17th April 2020

Your ref: **M25 Junction 10/A3 Wisley Interchange**

Our Ref: **Let1-170420-JB**

Re: Desktop review of the Highways England tree protection proposals at the M25 Junction 10/A3 Wisley Interchange

Drawing Title: OCKHAM PARK JUNCTION A3 NORTHBOUND ON-SLIP AMENDED ALIGNMENT ADJACENT TO RHS WISLEY
Drawing Number: HE551522 - ATK - GEN - A3_L1_ML - DR - ZM - 000001
Location: A1
Scale: 1:500
Project Ref. No.: 5158141
Sheet: 1 of 1
Rev: P02.2

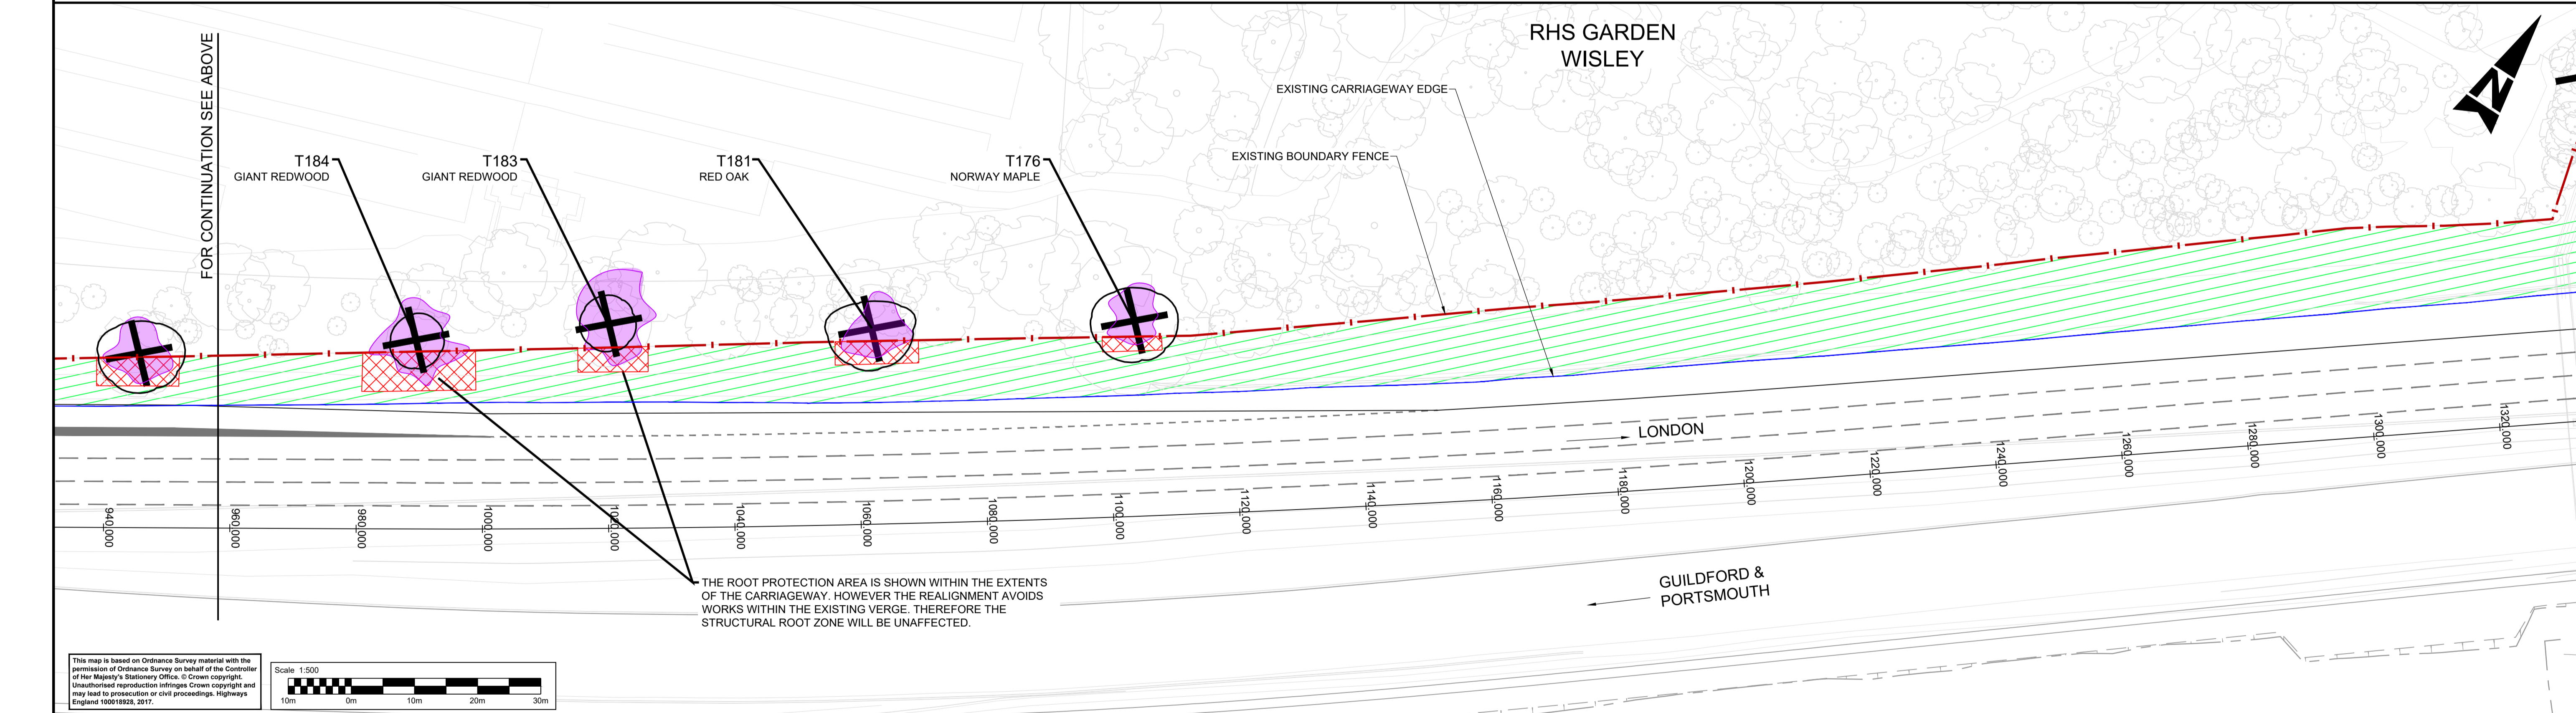
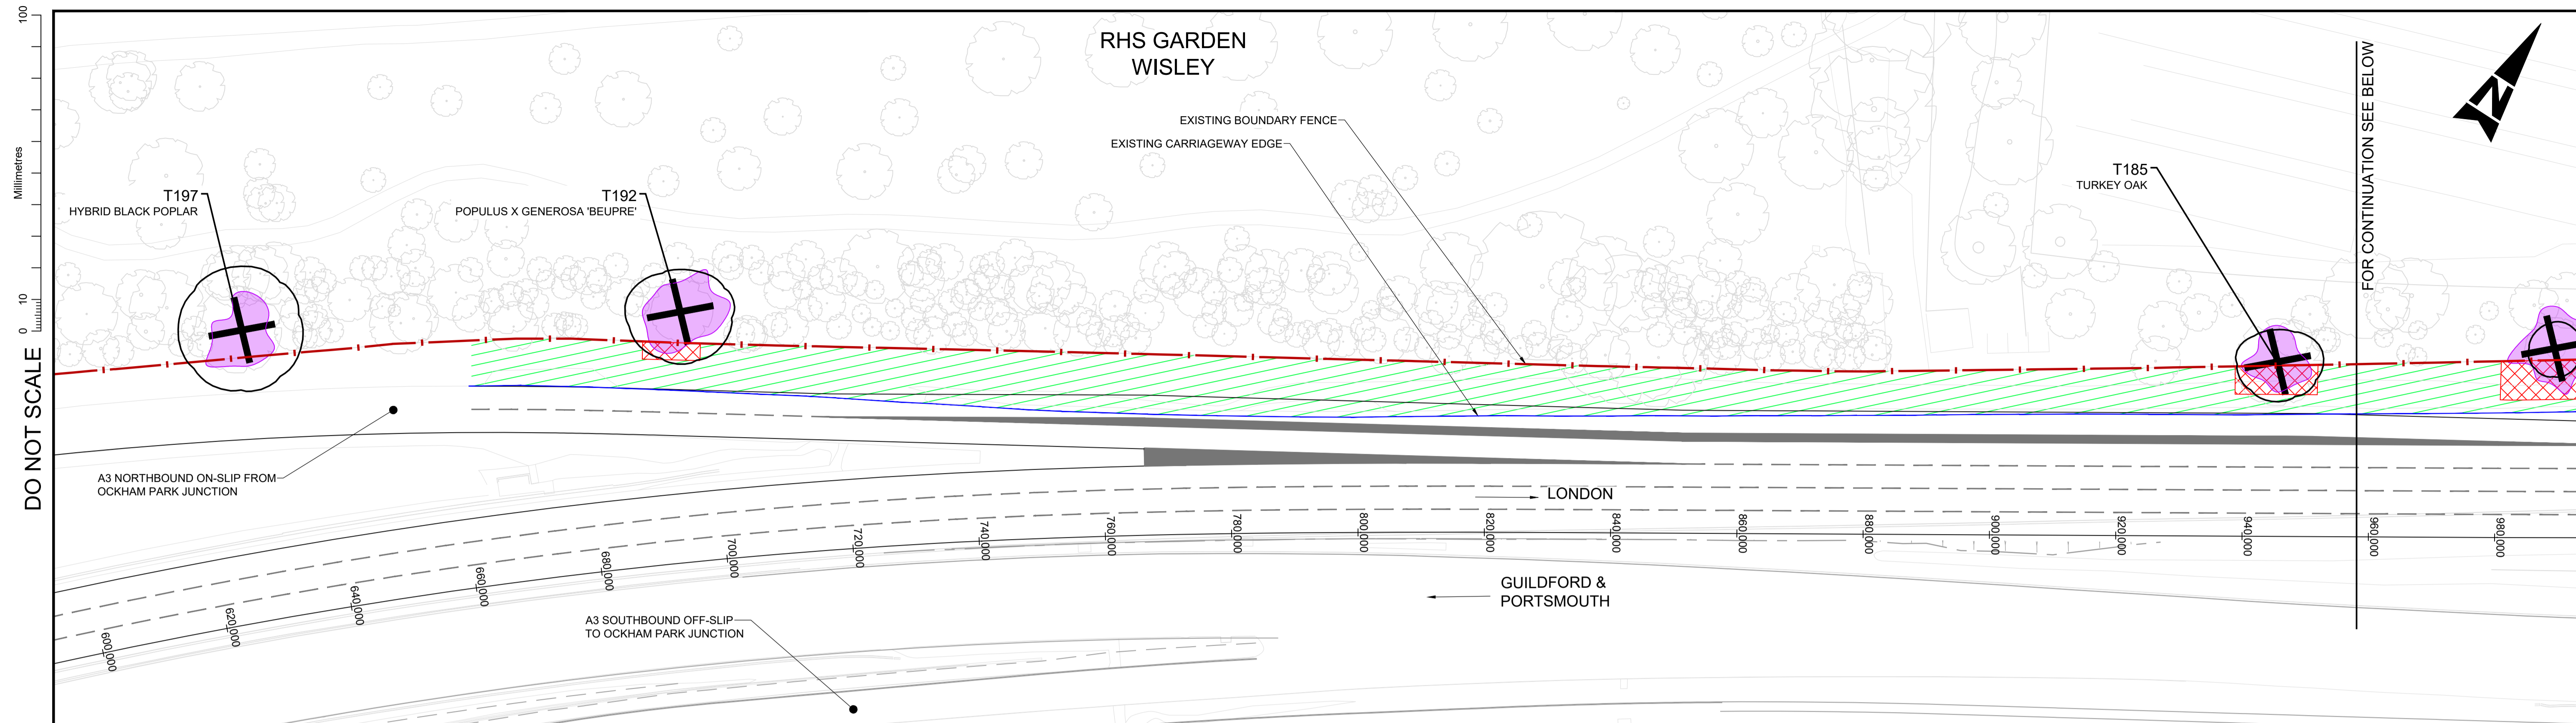
4. No explanation of the phrase '*structural root zone*', a term that is not mentioned or recognised in BS 5837.
5. No calculation of the root protection area (RPA) based on the recommendations set out in BS 5837. Of particular concern is the Section A shown on drawing number HE551522-ATK-GEN-A3_L1_ML-DR-ZM-000001-RevC01, where annotation on the not-to-scale section indicates a structural root zone of 1m depth, and a tree diameter of 1.79m for T184 (see further commentary below).
6. No tree protection measures have been detailed in an arboricultural method statement to show how trees will be protected from harm during development, as required by BS 5837.
7. Appropriate protection measures need to be applied to all the trees identified that could be at risk, and not just the redwoods.
